## Oulton Parish Council Comments on ISH 2 - Onshore Matters.

### Agenda items:-

TITLE
B1149 OULTON
DRAFT
ACC25 ACCESS CONCEPT
SWEEP PATH ANALYSIS

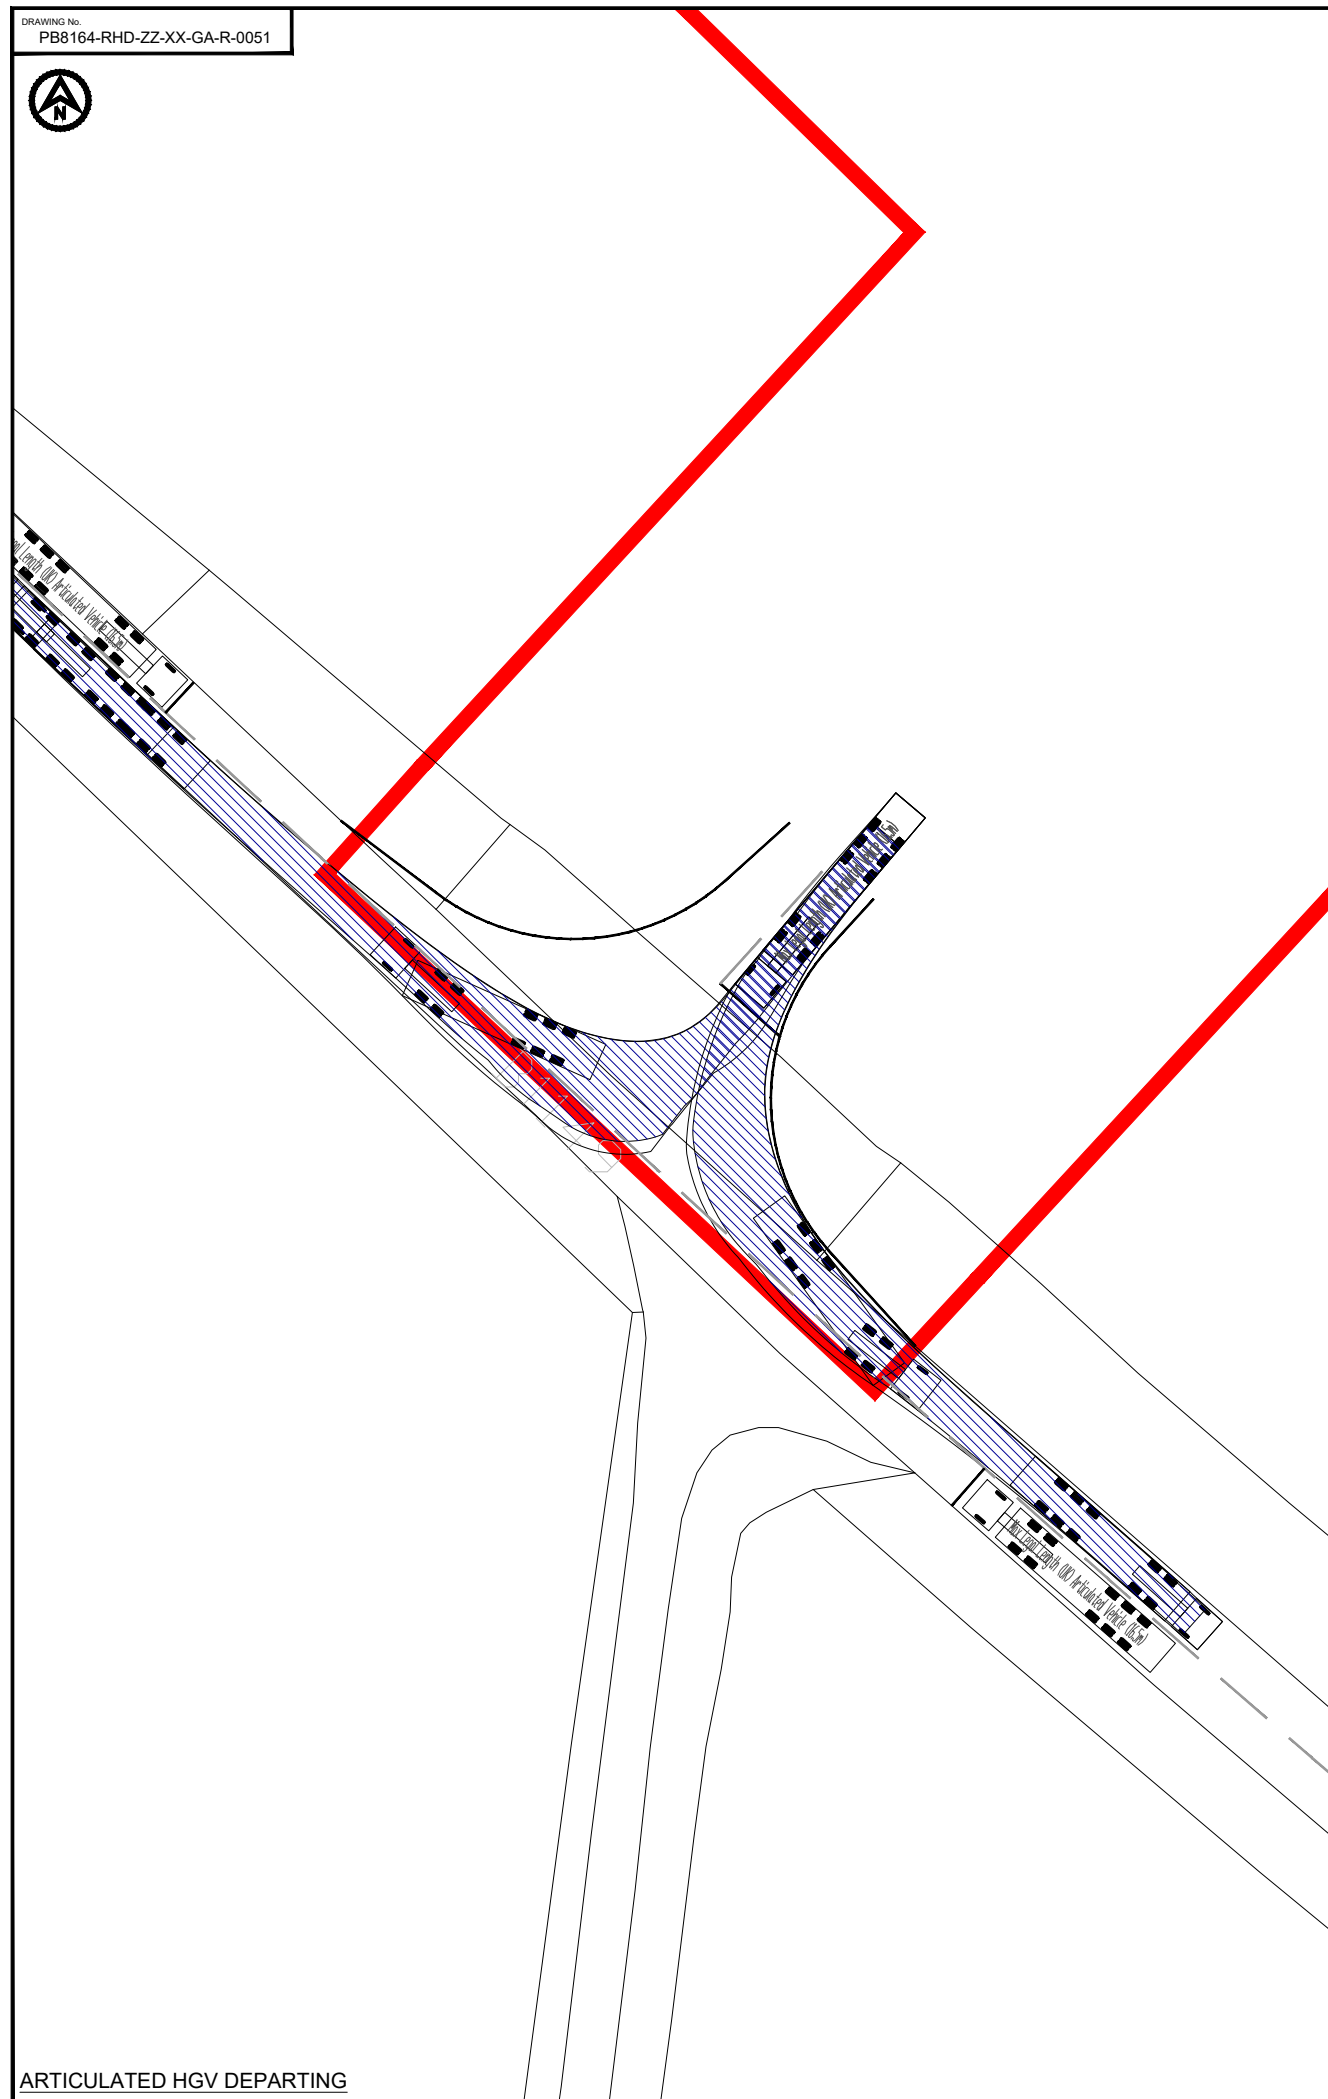
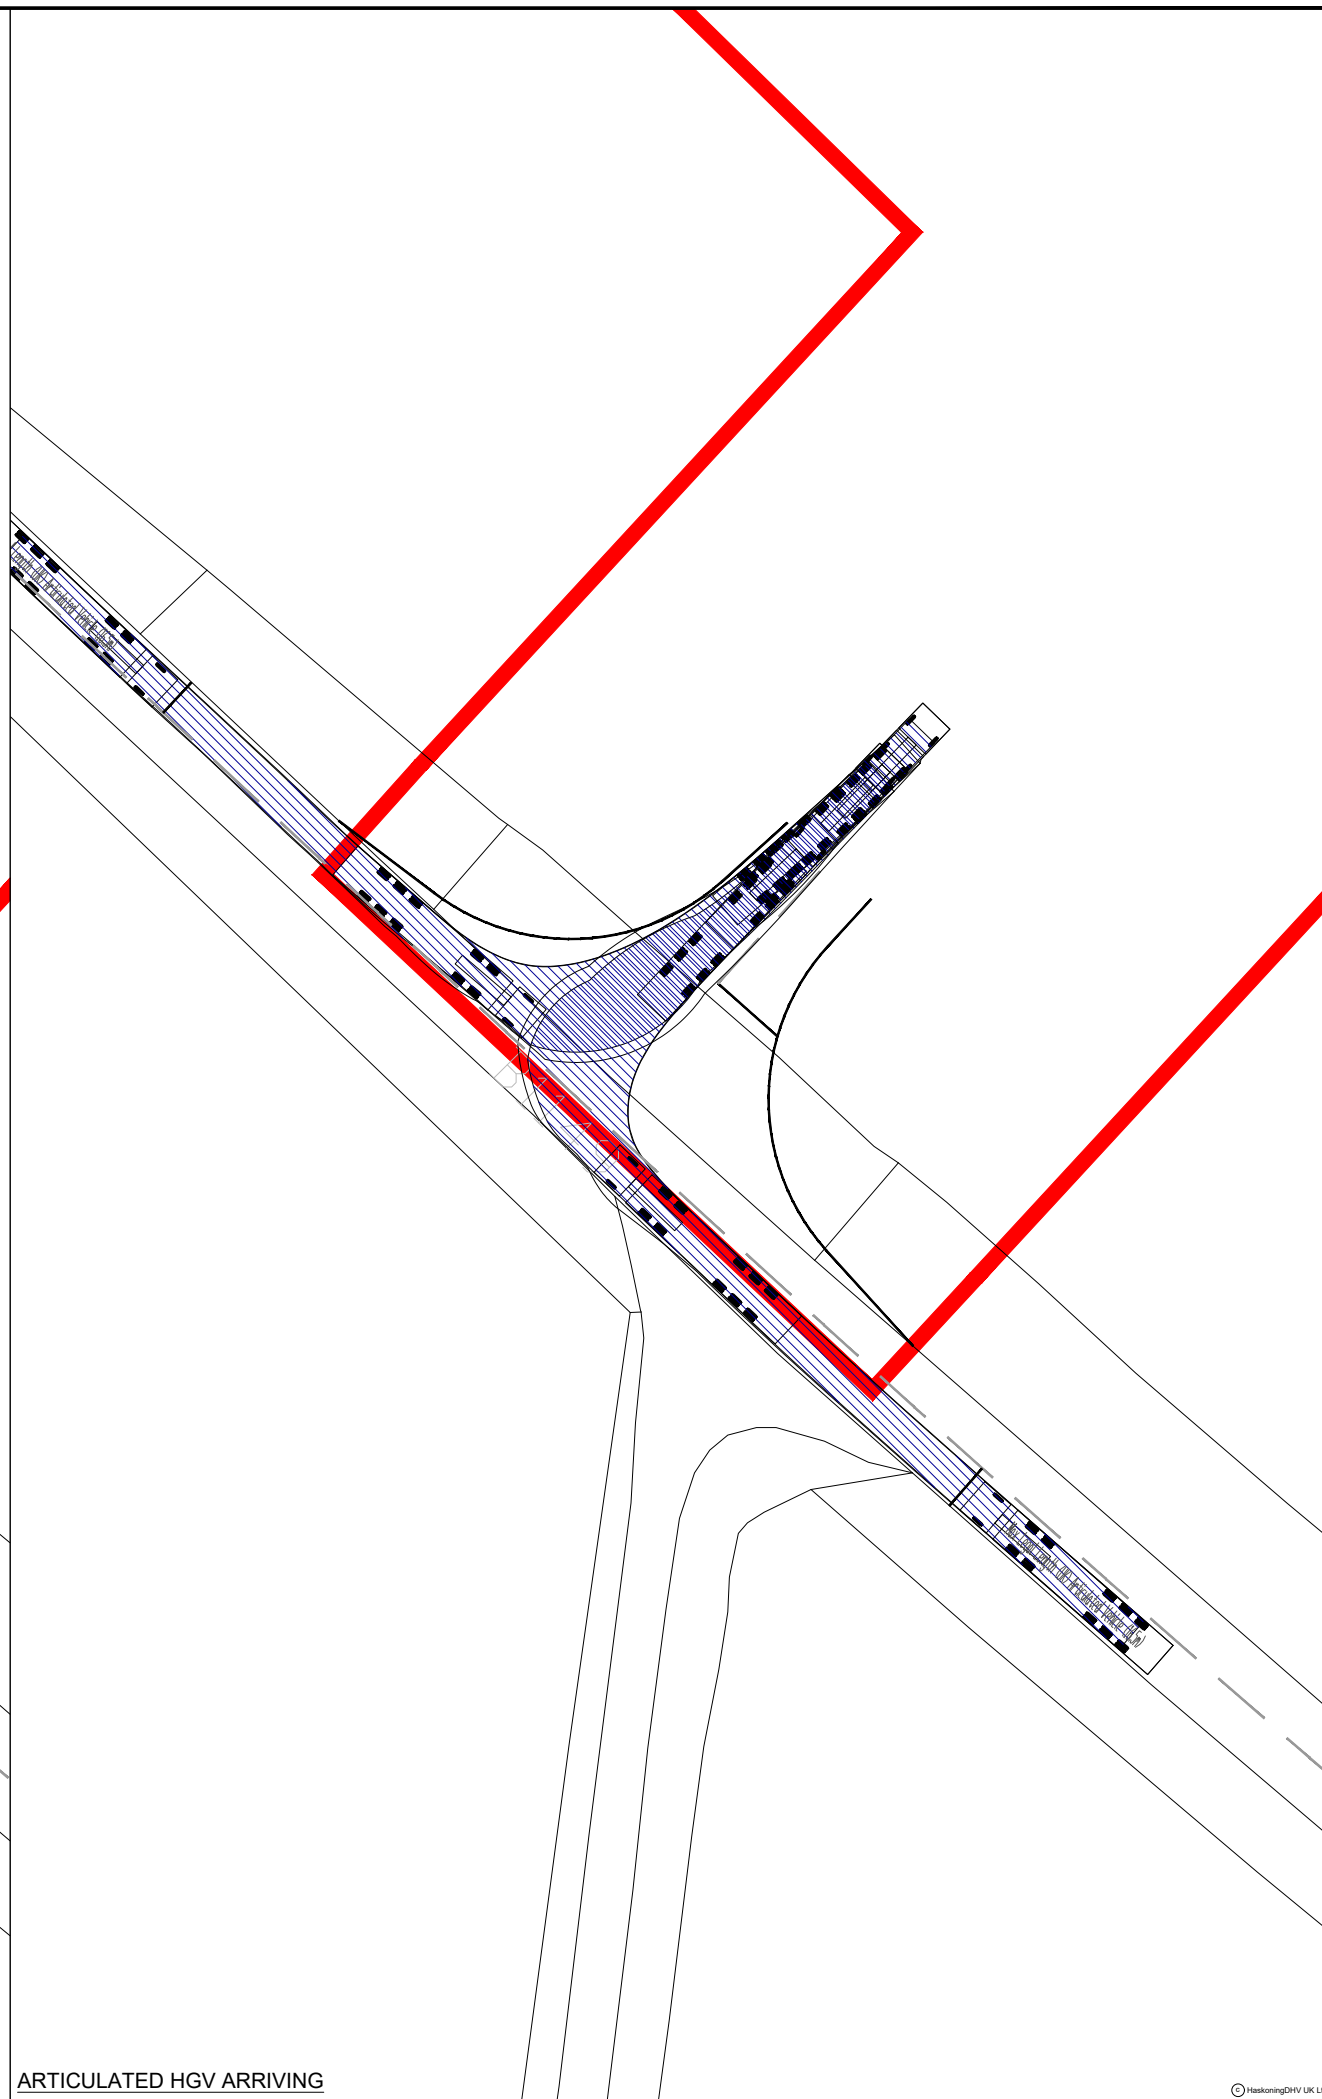
vi) OPC note that there are three access points along **B1149**...(\*see below)  
The B1149 will have cumulative traffic from HP3/Norfolk Vanguard/Boreas.

**(APP-014) \*ACC25**

DRAWING No. PB8164-RHD-ZZ-XX-GA-R-0014 REVISION

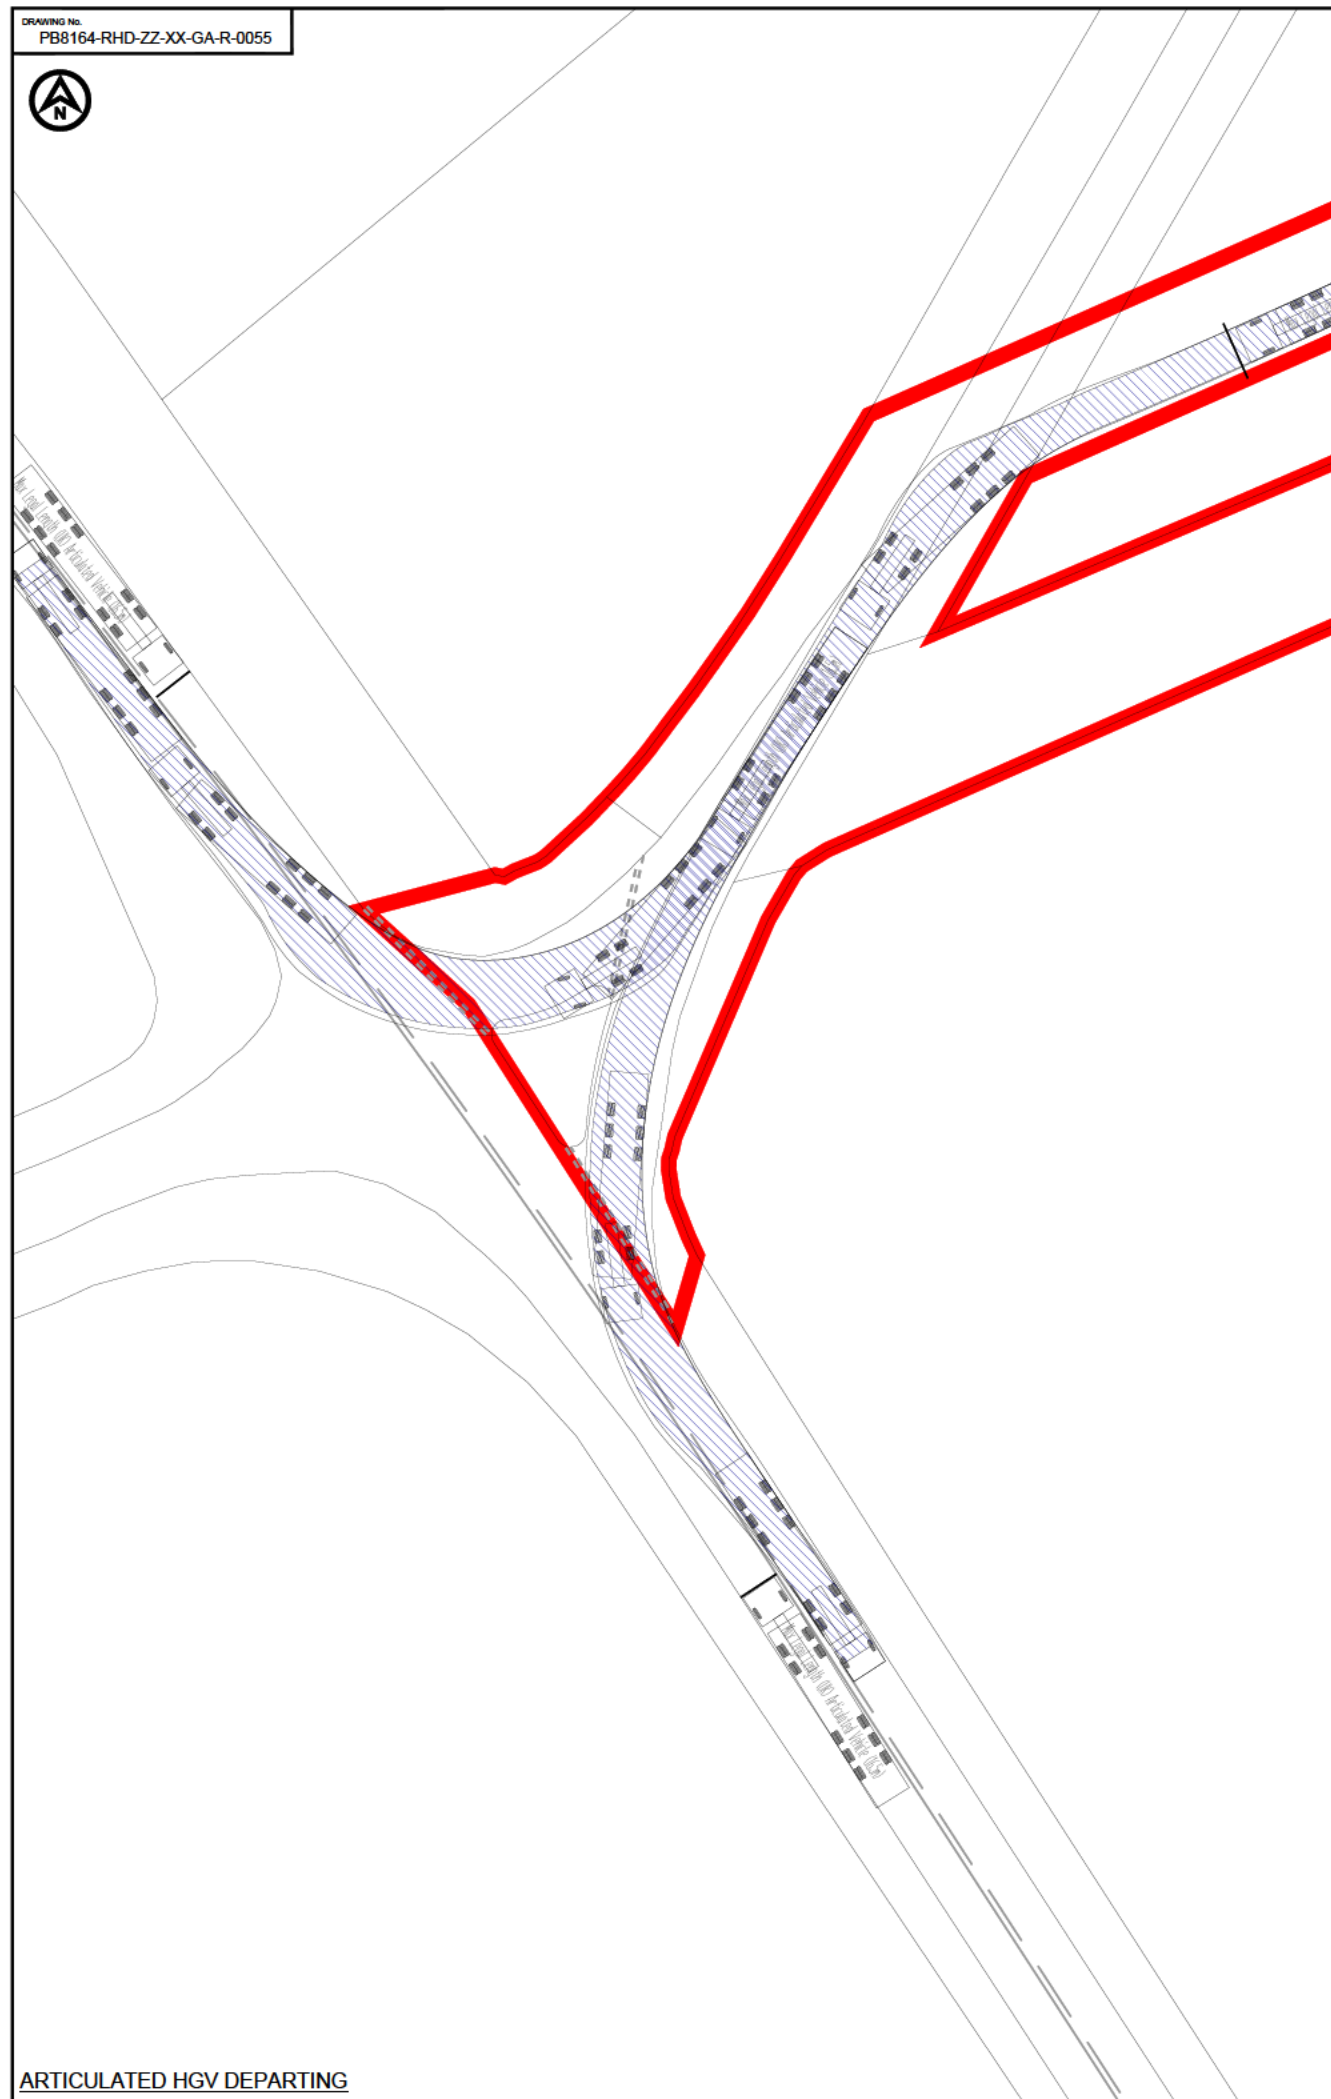
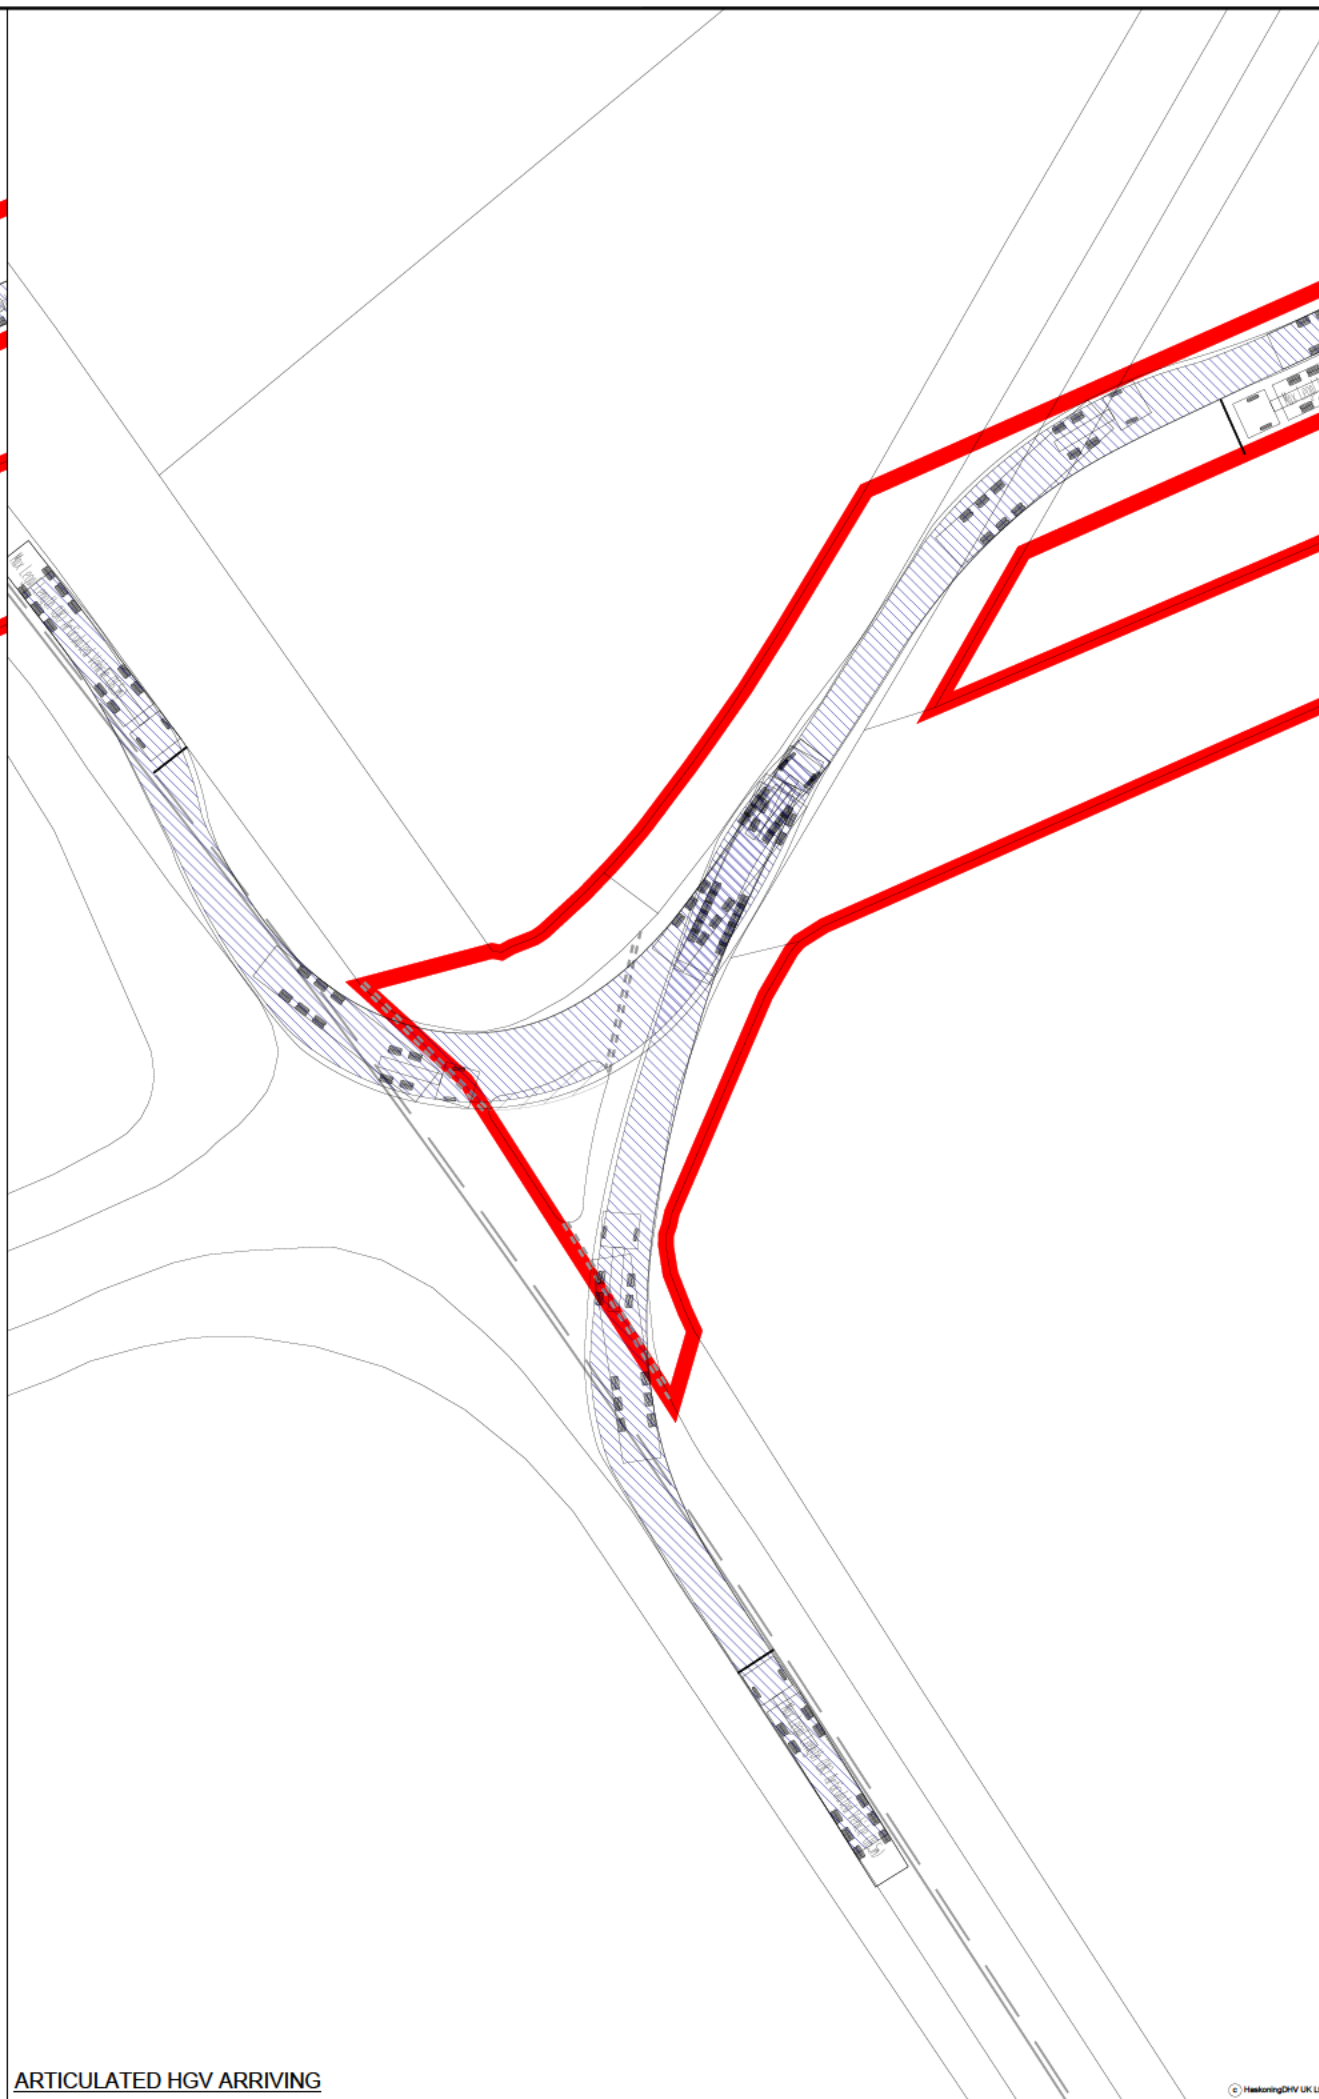
ii) For one property there will be the added cumulative impacts of not only traffic but the addition of HDD along side their property...**(CCR16C APP-133)**  
The other effected \*property will be experiencing HDD/and temporary loss of access to their property. Due to the proposed access to the cable route and HDD **(APP-014 ACC25b/ACEW42) (APP-133 CCR16B)**  
\*Bluestone Cottage

OPC would query whether the resident of this property has been consulted.

**(APP-014) \*ACC25b/ACEW42**
